BCA ASSESSMENT REPORT

PROJECT: HKH STAGE 2

HEALTH INFRASTRUCTURE

Ref.: 170370

**LEVEL 5
OVERALL PLAN**

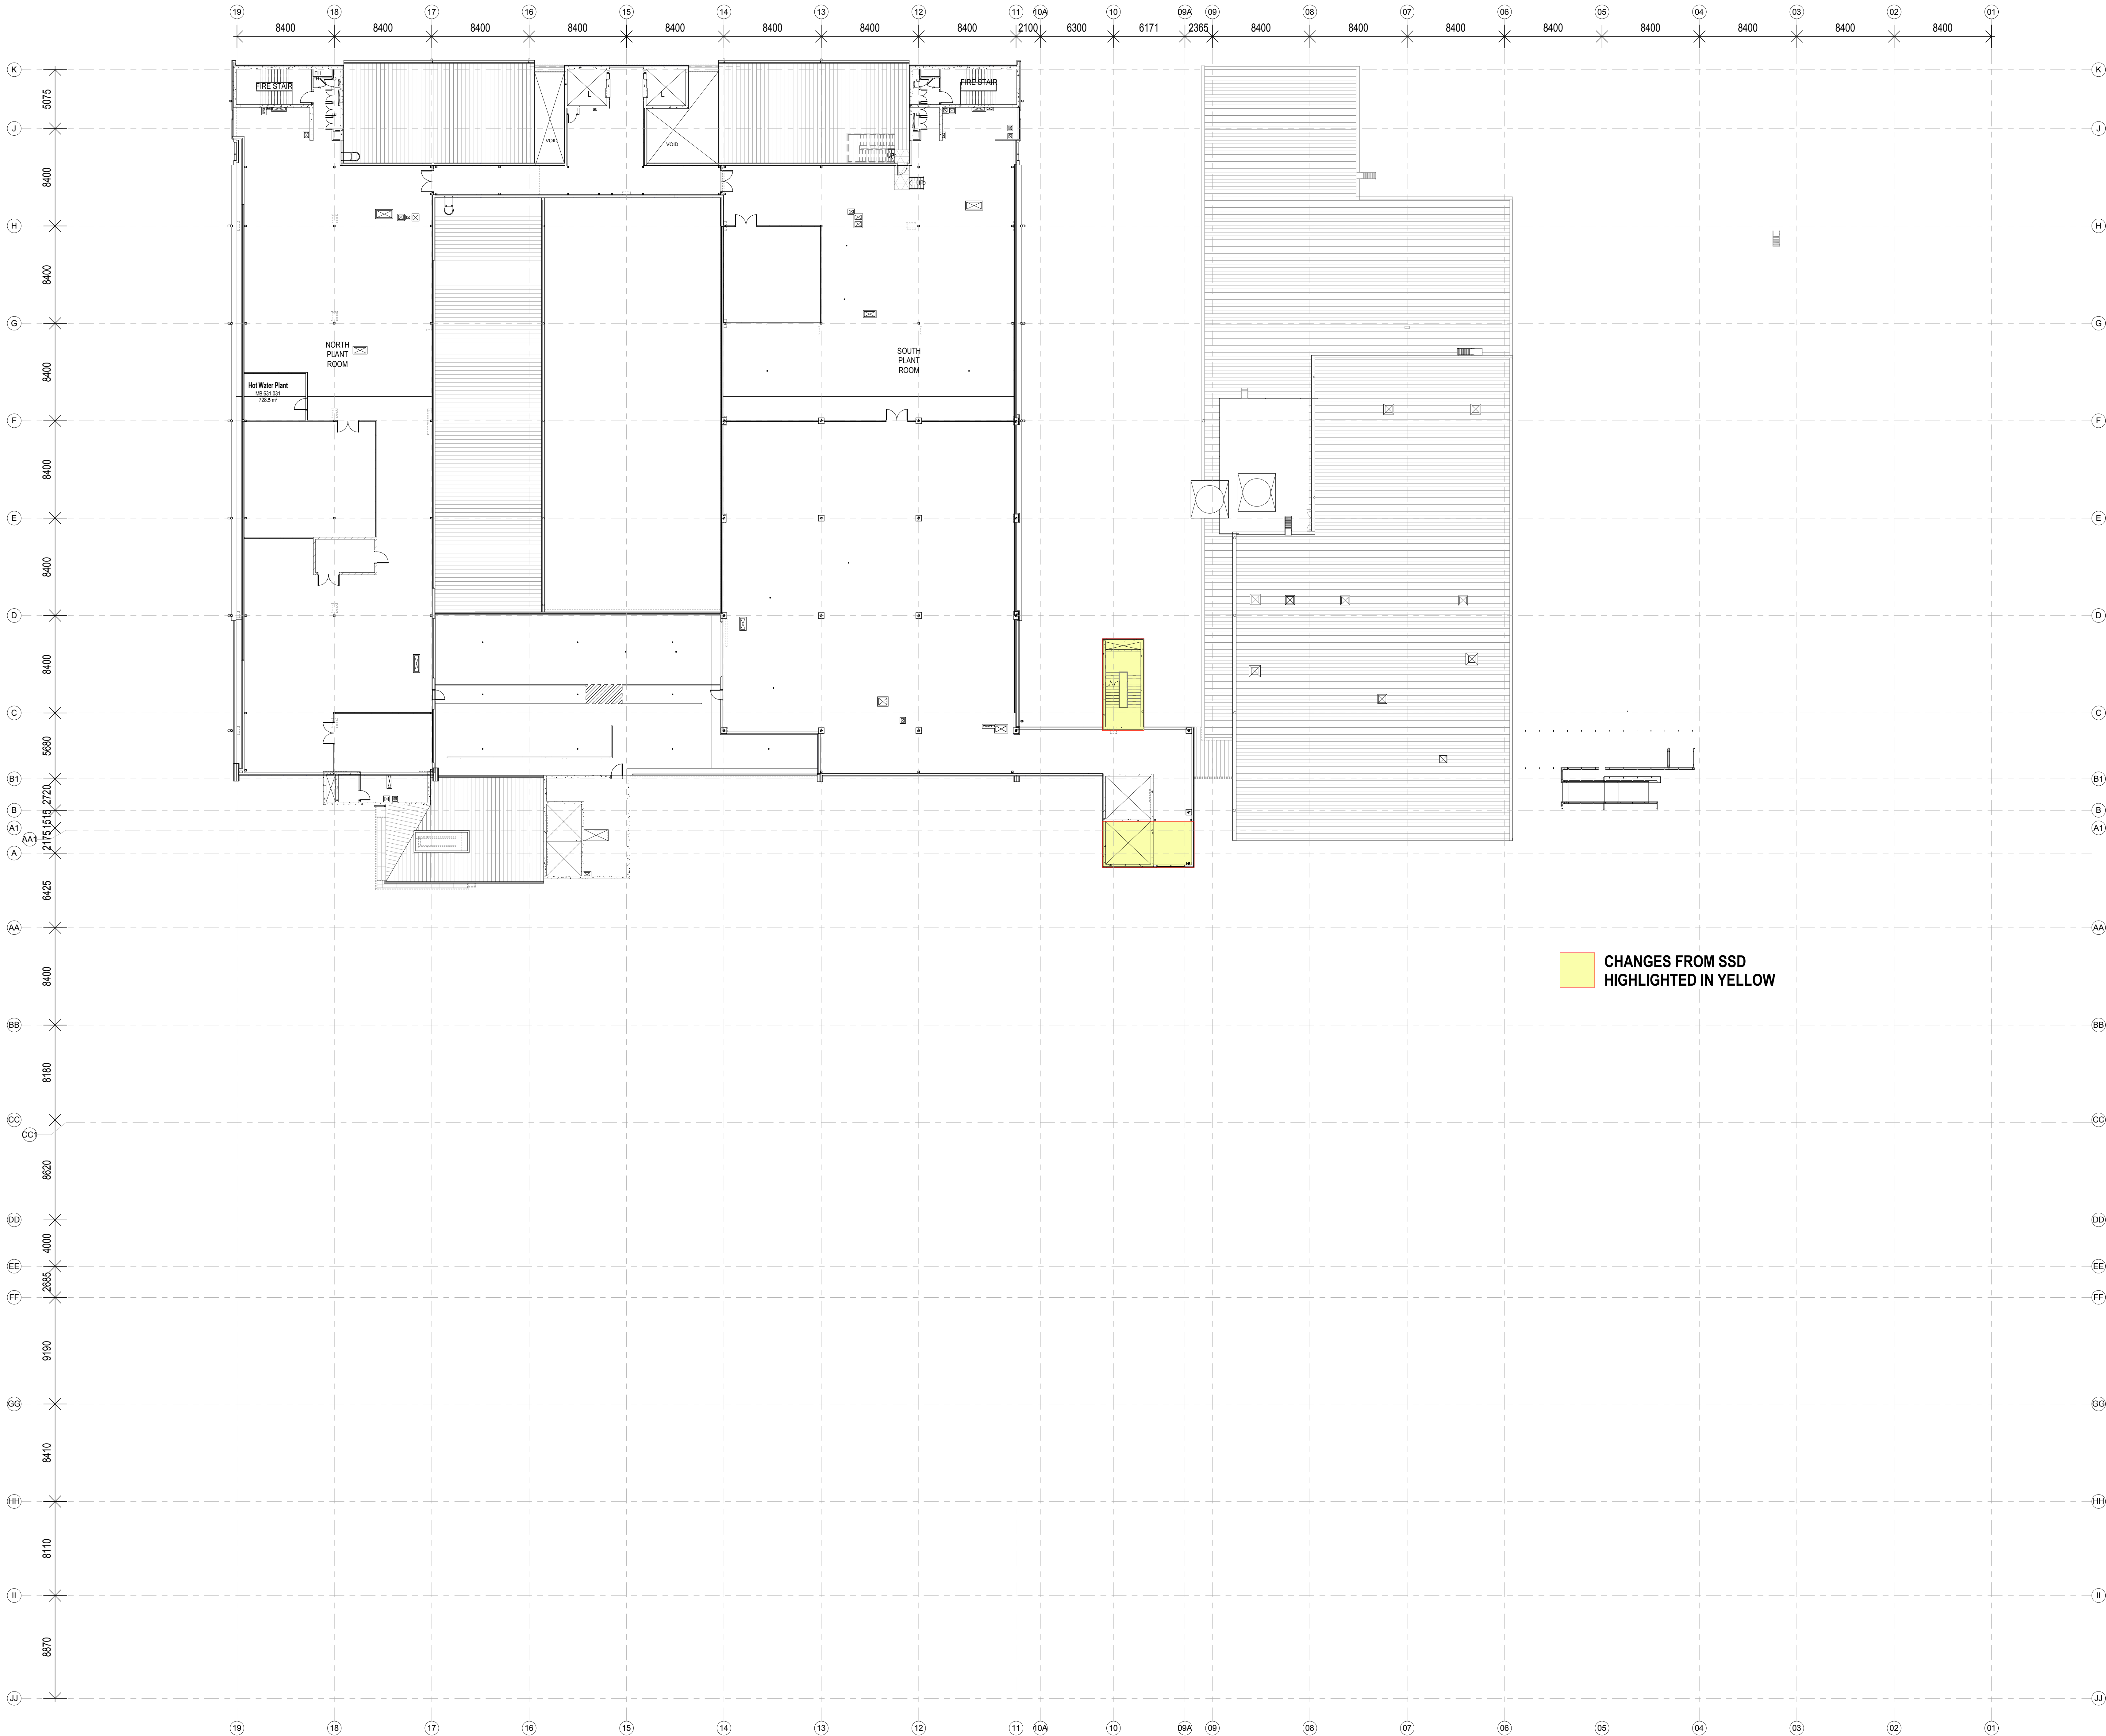
3.	D1.4 / D1.5	Paths of travel in at least 2 directions are required from each of the enclosed courtyards. Level 5 future fitout is to take into account maximum distance to a point where a choice of alternative exits is available of 20m. . Fire walls are to be introduced into Level 5 and also Level 6 to create additional exits to address extended distances to exits and extended distances between alternative exits.
